Application no: **3/2022/0589**

Address: **1 Ribble Lane Chatburn BB7 4AG**

Proposal: **Proposed double driveway and dropped kerb to the right side of the front of property.**

The Local Highway Authority have viewed the plans and highway related documents and have the following comments to make:

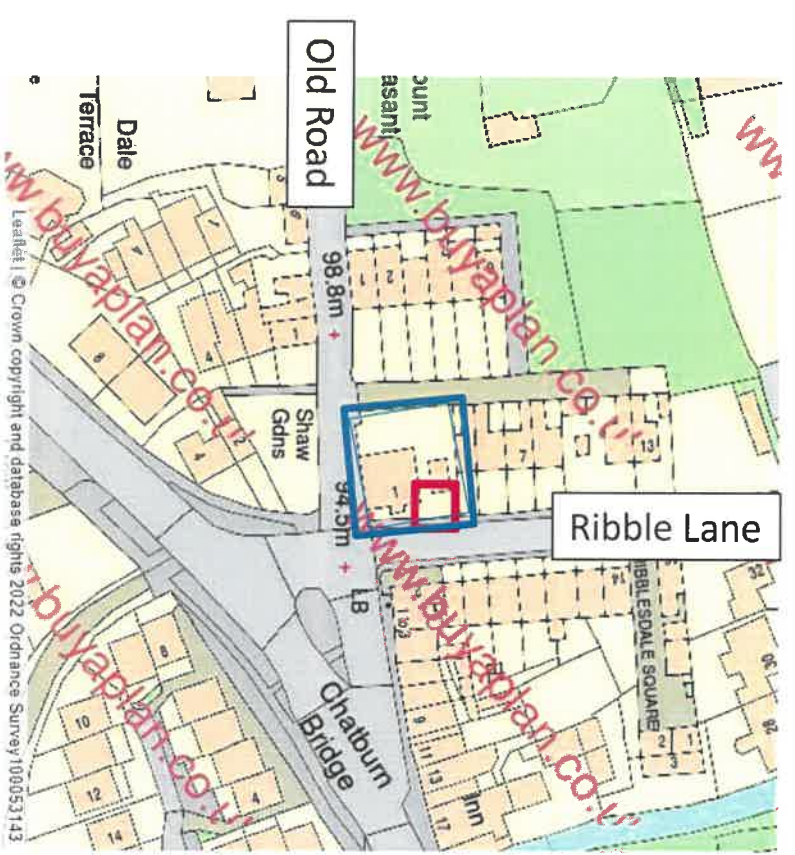
The LHA have reviewed the drawing titled "Proposed Site Plan" and are aware that a 7.4m dropped kerb is required to provide access to the 6.5m wide driveway which will serve the two proposed car parking spaces.

The LHA are aware that the access will conflict with an existing streetlight and an existing bus stop. Despite this the LHA are aware that the LHAs Streetlighting team and Bus Services Team have no objection to the relocation of both of these services. However, the LHA makes the Applicant aware that they will be liable to the full cost of relocating both of these services further along Ribble Lane. The relocation will all be undertaken under a Section 278 agreement.

However, by reviewing the drawing titled "Proposed Site Plan," the LHA are unable to support the creation of car parking space 2. This is because the length of the car parking space is only 4.5m. This does not comply with the Vehicle Crossing Guidance which requires the length of a driveway to be a minimum of 4.8m. Therefore, the LHA require the car parking space to be removed and the site only providing one car parking space, with car parking space 1 complying with the LHAs guidance.

Alternatively, the LHA advise the Applicant that they relocate or demolish the existing garage to provide the minimum length for a car parking space. Should the Applicant wish to relocate the garage, the LHA would advise that the garage is relocated a minimum of 0.3m further into the garden.

- Only provide one car parking space on the proposed driveway.
- Remove the existing garage to provide the required length for a car parking space.
- Relocate the existing garage 0.3m further into the site to provide the minimum length for a car parking space.
